From: [Frank Ho](#)
To: [Zach Torrance-Smith](#); Danchappelle@yahoo.com
Cc: [Lissy Hamm](#)
Subject: RE: Variance VA-23-00007 Chappelle
Date: Thursday, October 12, 2023 12:54:18 PM
Attachments: [image001.png](#)
[10-12-23 Chappelle site map before Variance.pdf](#)

To: Danchappelle@yahoo.com; Frank Ho <frank@merleinc.com>
Cc: Jamey Ayling <jamey.ayling@co.kittitas.wa.us>; Chace Pedersen
<chace.pedersen@co.kittitas.wa.us>; Bradley Gasawski <bradley.gasawski@co.kittitas.wa.us>
Subject: Variance VA-23-00007 Chappelle

Drawing name: **PRELIM SITE MAP**

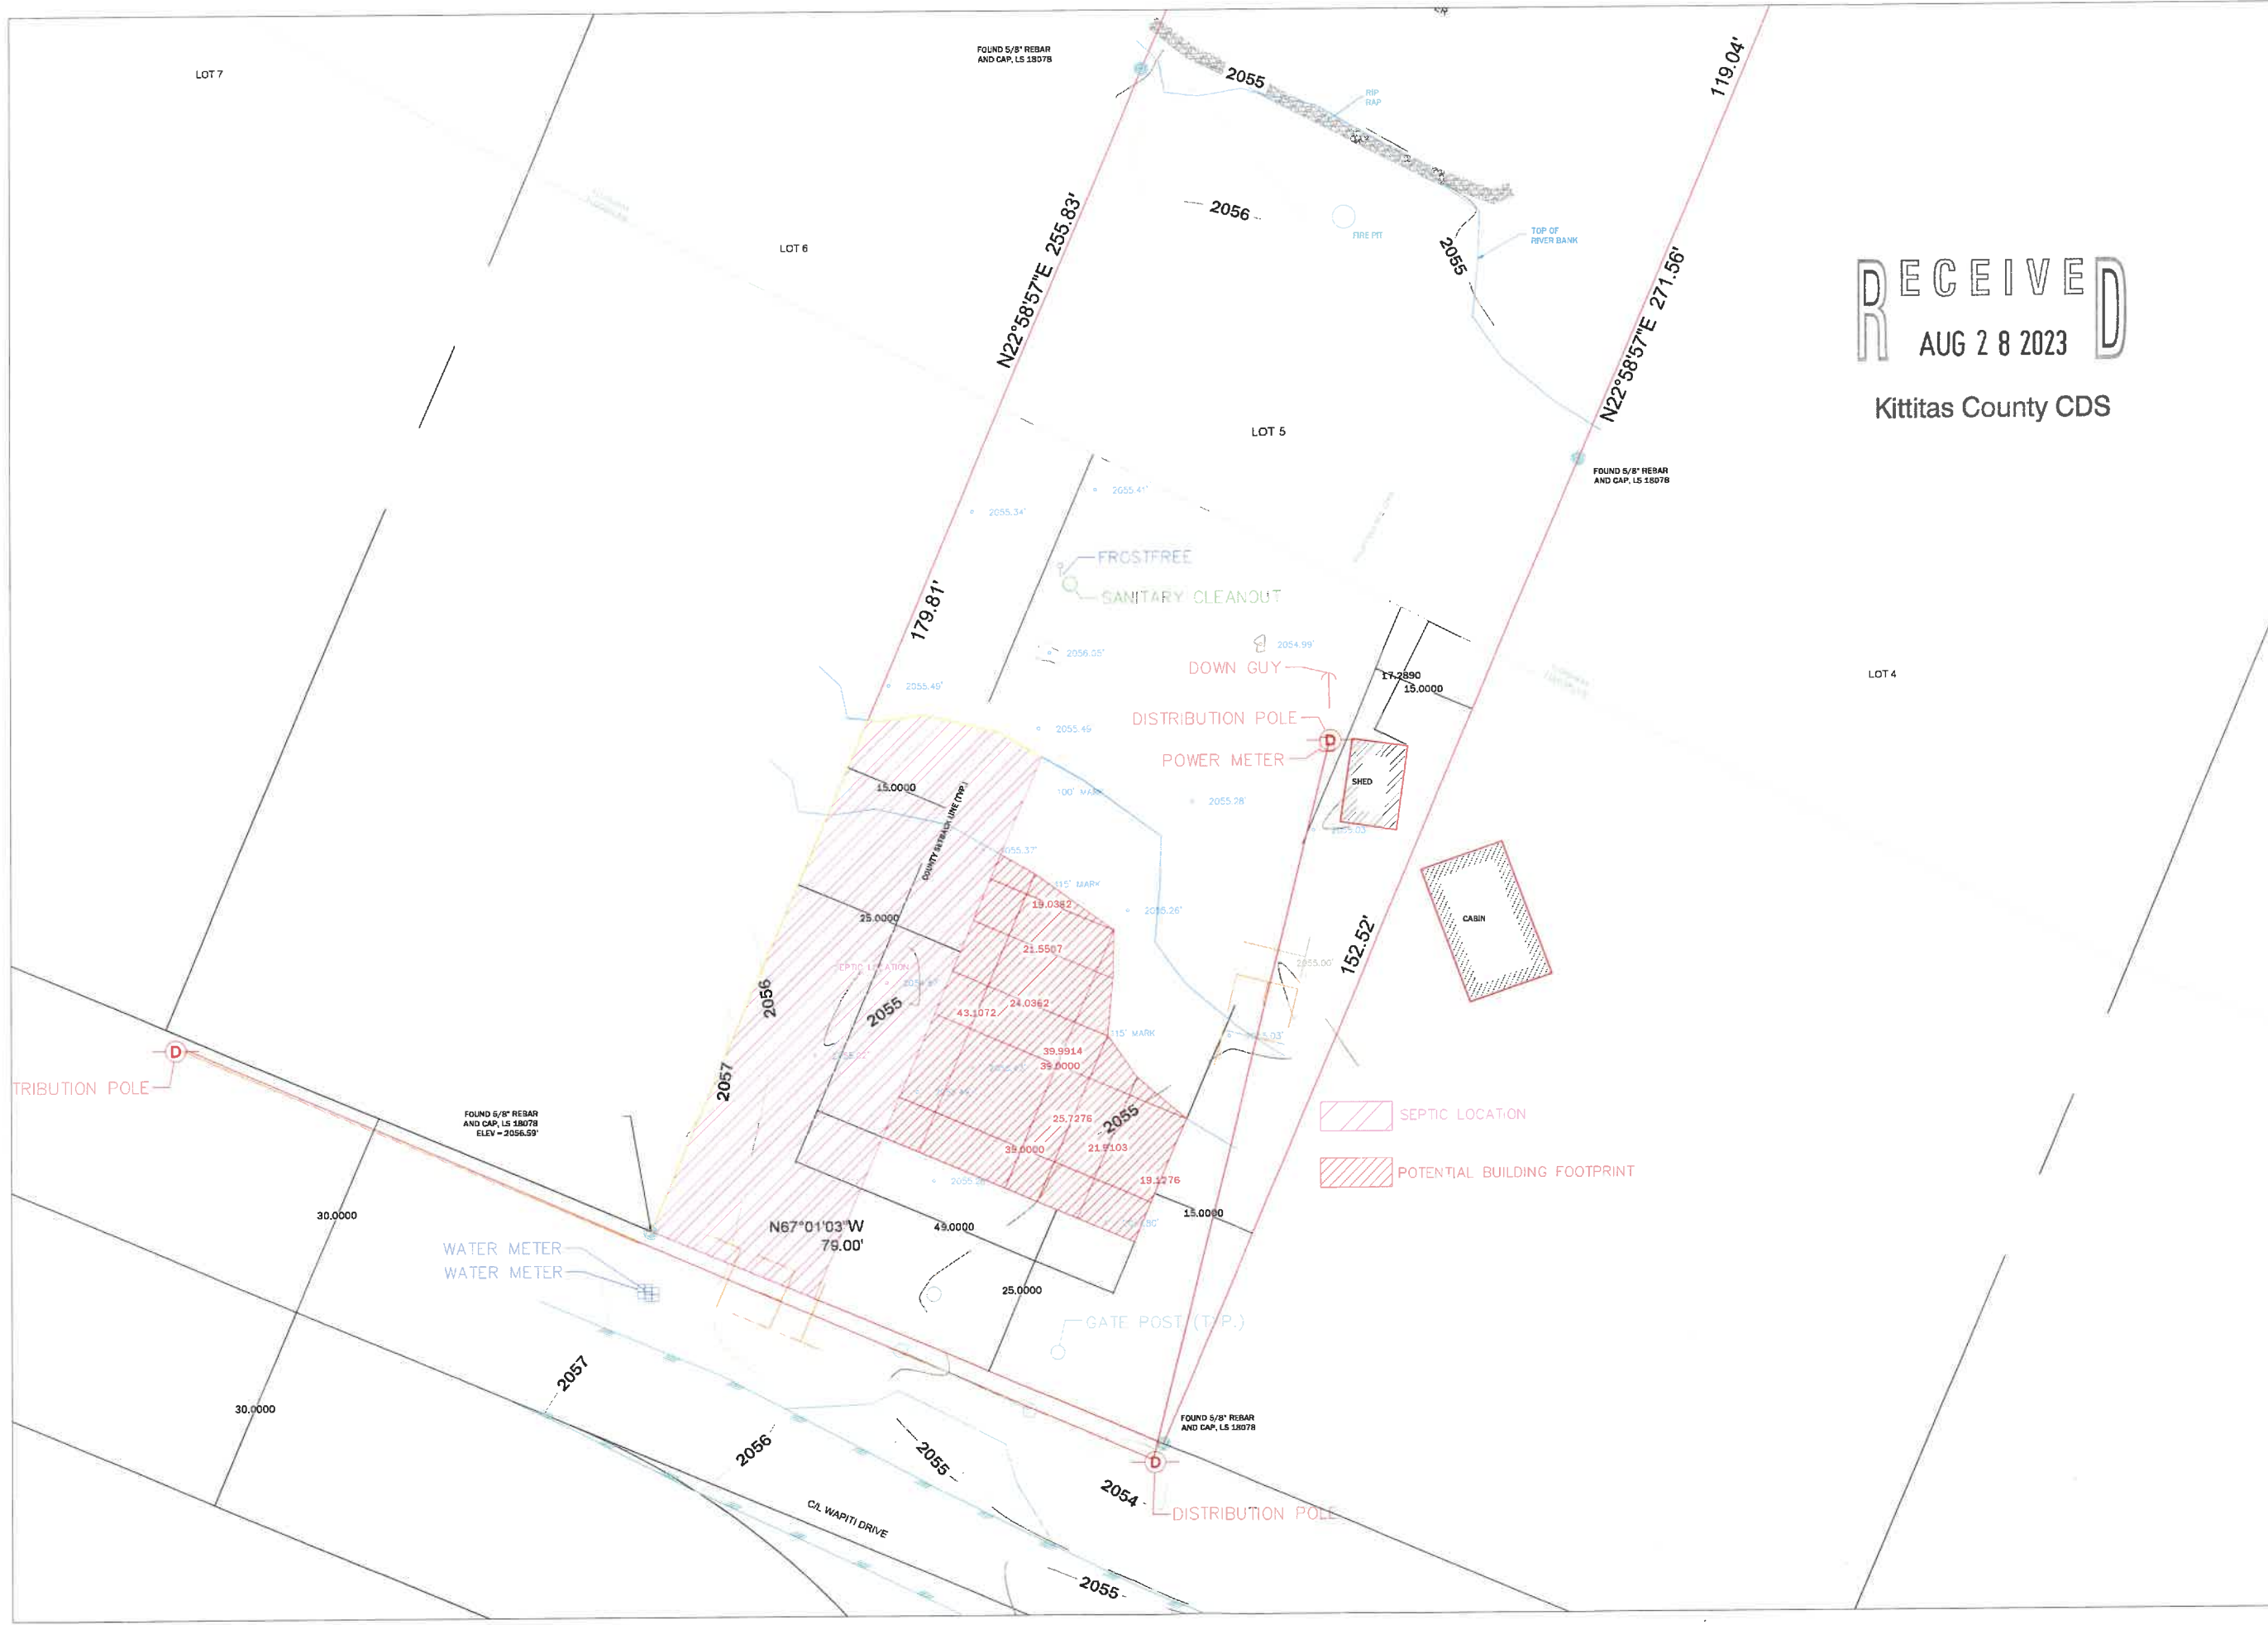
- Comment from Public Health Inspectors: A site evaluation was conducted on August 4th to confirm septic size and location. Please see the attached site plan which highlights the newly proposed septic location.
- Comment from Brandon Leyritz at PSE: We will redirect the power line underground directly from the street to the house. As well as relocating the meter to the home.
